21 October 2022

Our Ref: R/2021/10/B  
File No: 2022/542843  
Your Ref: SSD 32927319

## **Powerhouse Ultimo Renewal – Stage 1 – Advice on Response to Submissions**

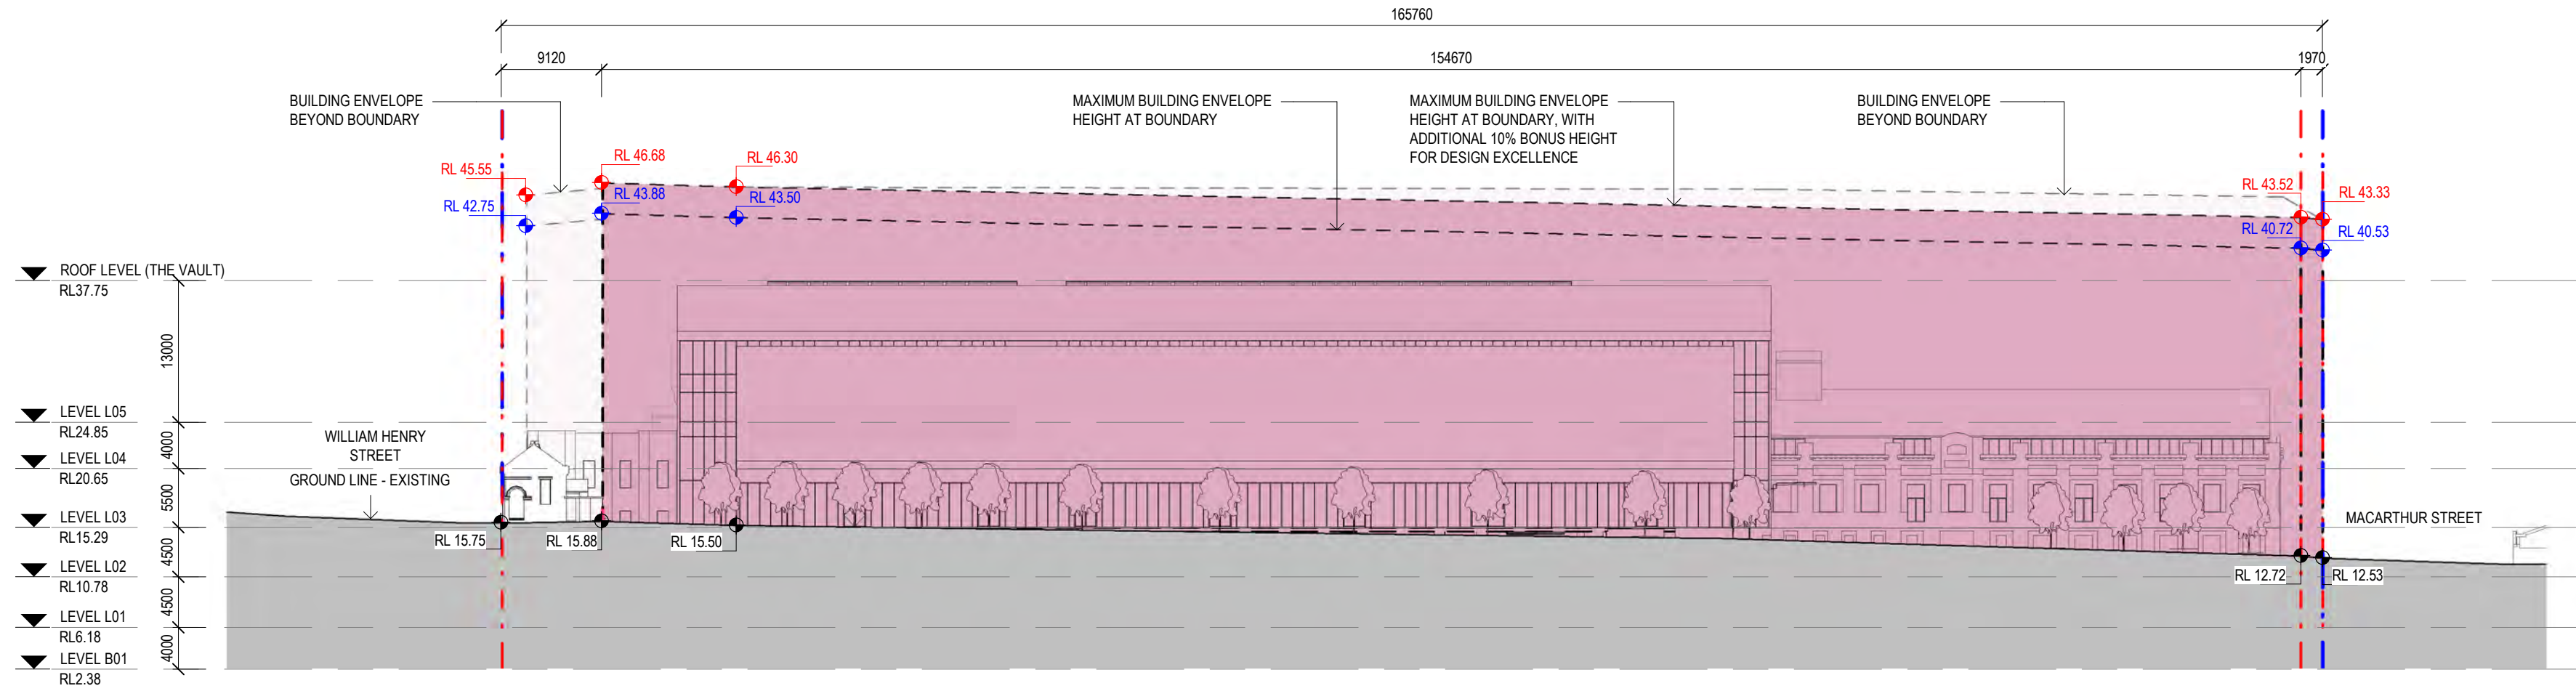
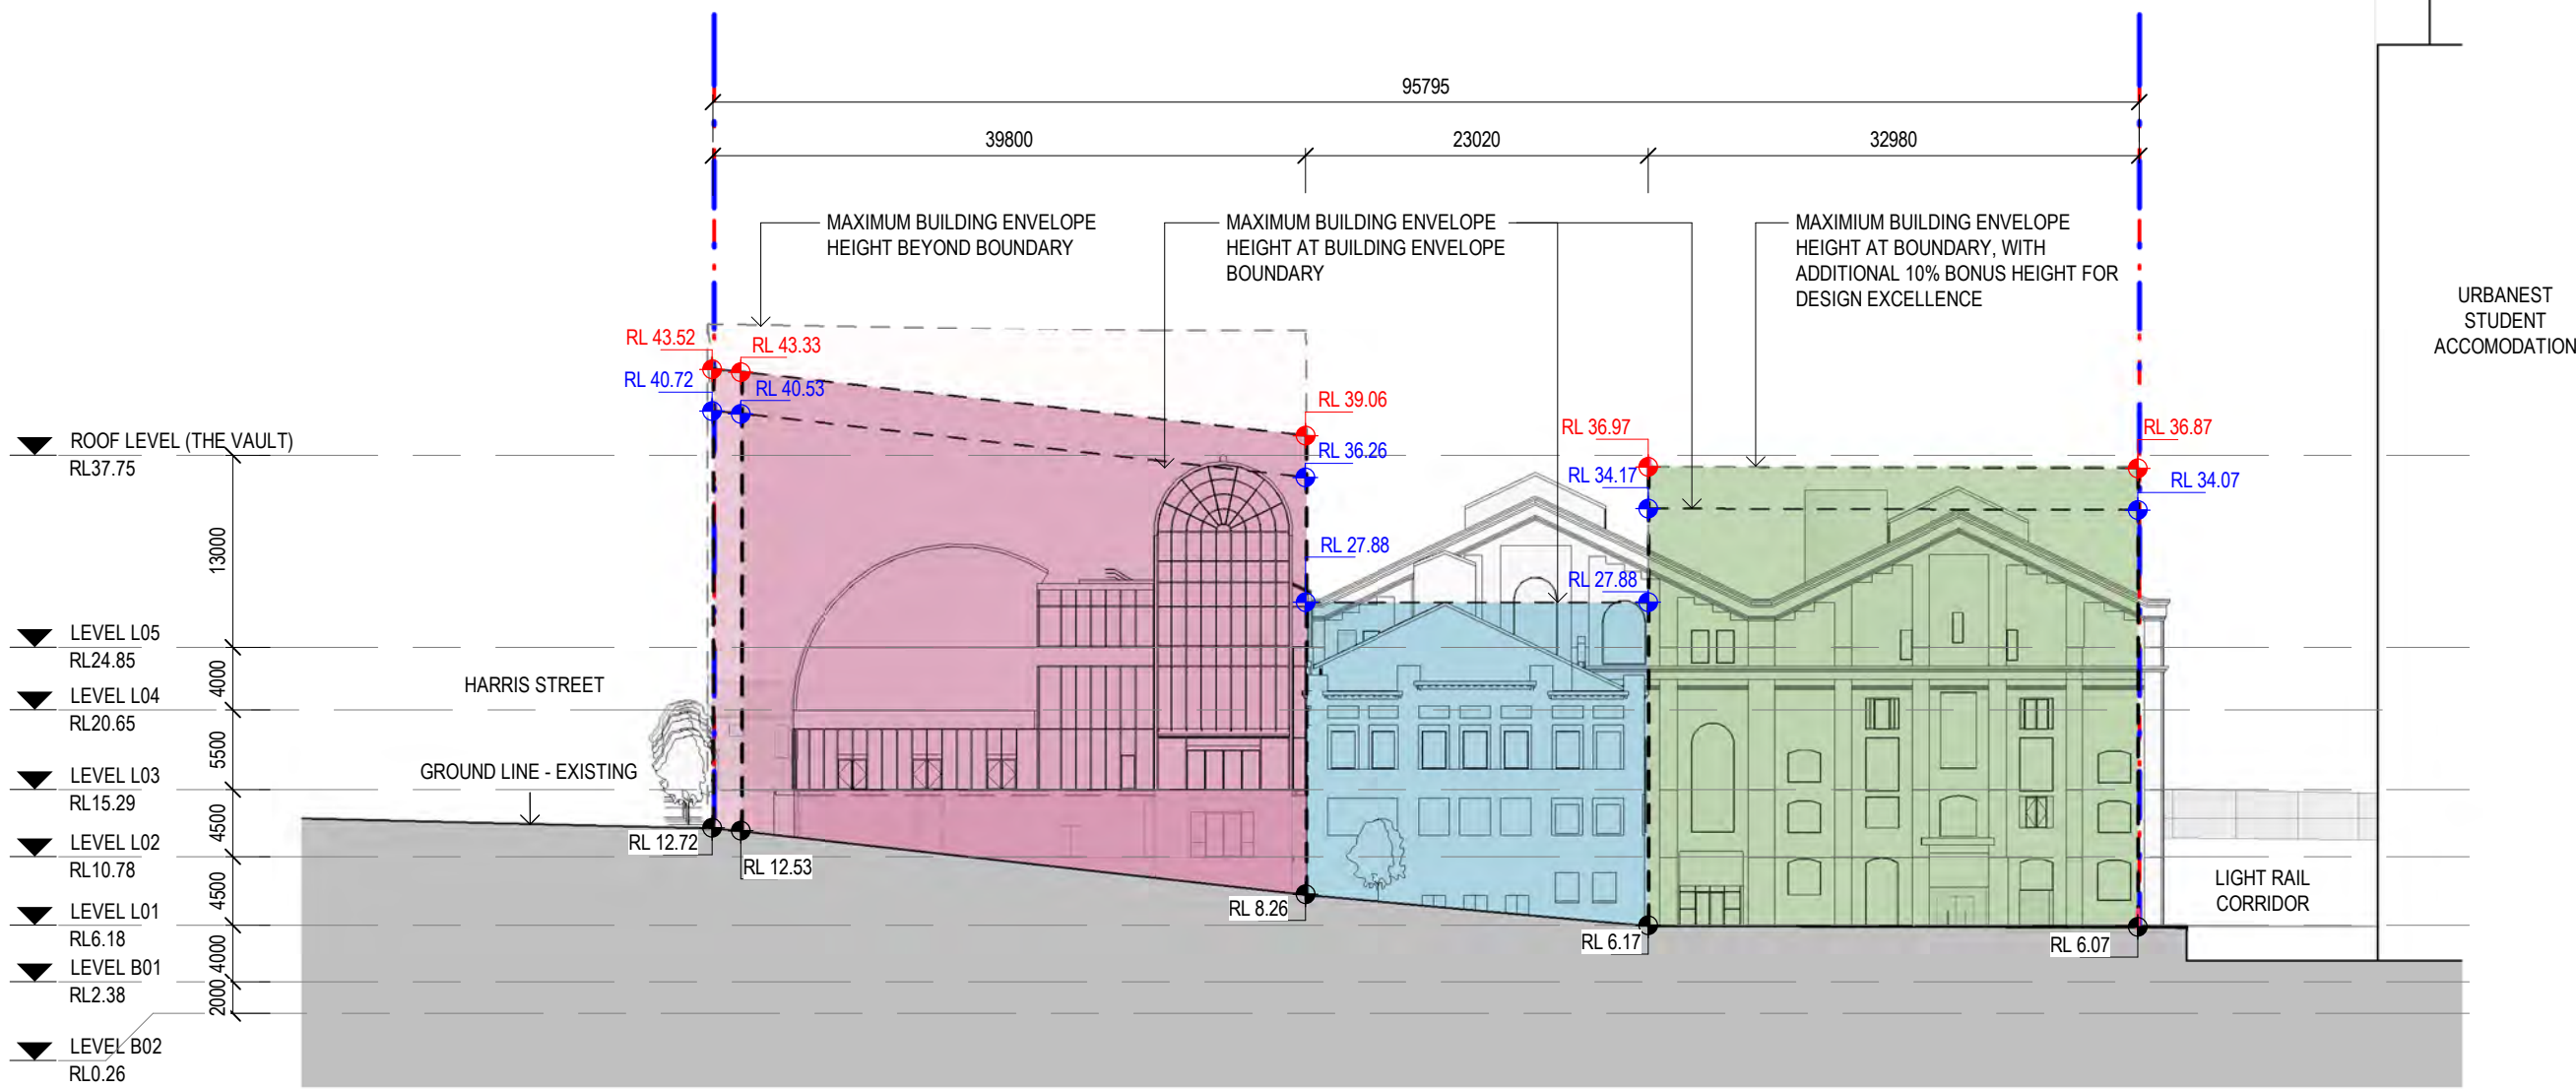
The RtS provides additional information including revised building envelopes (Appendix C) and revised Urban Design Guidelines (Appendix D). While the revised envelopes include the removal of any additional envelope over part of the site (Heritage Core and Former Post Office), and have been reduced above the Switch House, the City recommends that further analysis is required to determine the appropriate form of envelopes. Further analysis should include:

As earlier stated, the City supports the amended building envelopes as provided in Appendix C of the RtS as they remove any proposed building envelope above the State and Local Heritage Items (except in the location of the existing rooftop mezzanine addition above the Switch House) clarifying that no new buildings are proposed in these zones.

However, the City maintains that any proposed building envelope above additional parcels of land should be carefully considered or minimised, and that to date, insufficient justification has been provided for proposing additional height over these parcels of land.
